Northside Private Hospital, West Gosford (SSD-10159) (Central Coast)

Thank you for your request via ePlanning Portal (ref: PAE-2085) dated 18 February 2020 requesting Transport for NSW (TfNSW) review and comment on the Environmental Impact Statement (EIS) supporting a State Significant Development (SSD) application for Northside Private Hospital, West Gosford.

ATTACHMENT A

Figure 37 Bicycle and Pedestrian Shared Path in Stage 1

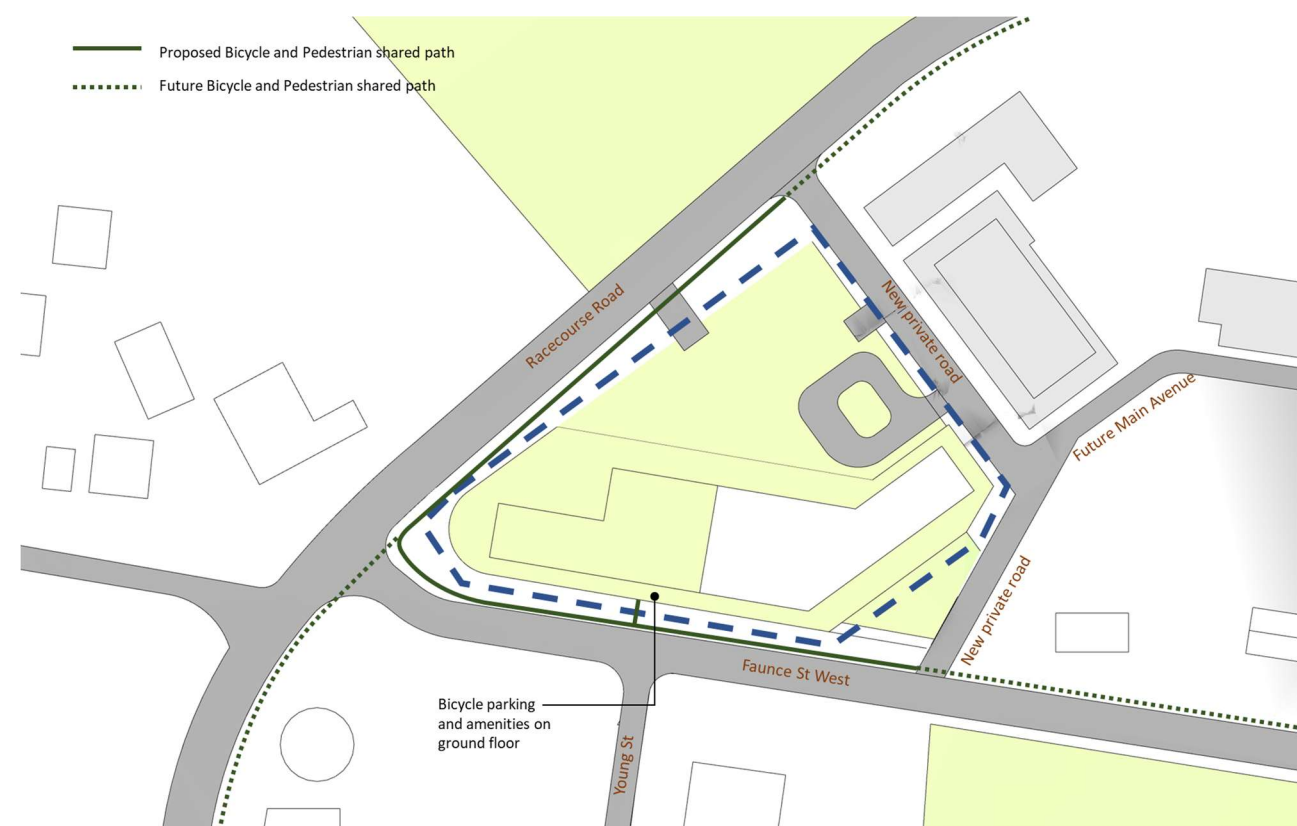
It is requested that the applicant be conditioned to provide bicycle parking and end of trip facilities for staff and customers in accordance with Gosford Council Development Control Plans, standards and guideline documents including:

- Locate bicycle facilities in secure, convenient, accessible areas close to the main entries incorporating adequate lighting and passive surveillance and in accordance with Austroads guidelines;
- Provide signage/marked walkways to the hospital from the car park; and
- Update the Architectural package to show where these facilities will be located.

Figure 39 Vehicular Traffic in Stage 1

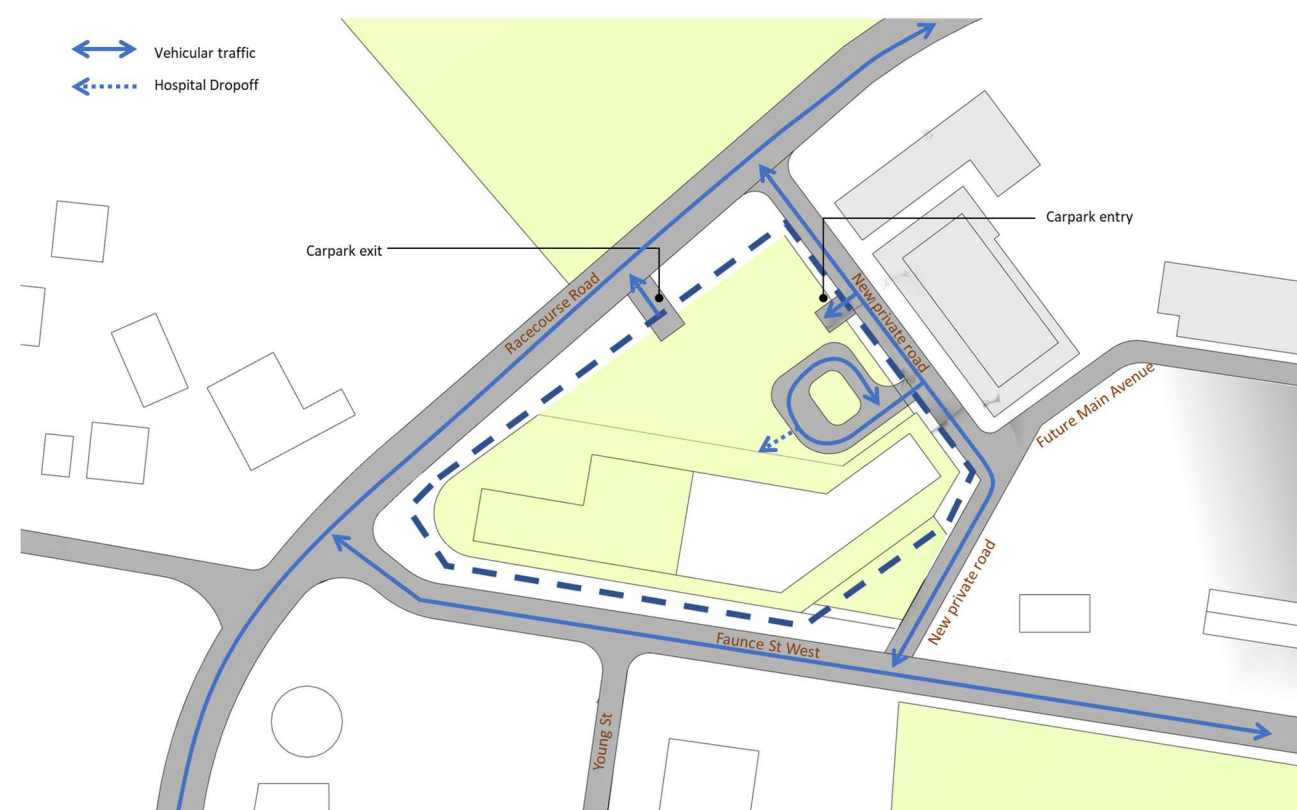
TfNSW does not support access to Racecourse Road in the location proposed. The sight of the proposed access is compromised by the alignment of Racecourse Road, and accesses to the classified road corridor should be limited.

The seagull intersection proposed with the site access (Table 11) is not appropriate for an urban location, and the width of Racecourse Road would not allow for a seagull compliant with Austroads Guidelines to be provided.

It is requested that the applicant be conditioned to provide all access to Northside Private Hospital to / from Faunce Street, and an upgrade of Racecourse Road and Faunce Street should be provided to Council's requirements. Additional emergency vehicle only direct access to Racecourse Road can be considered subject to design.
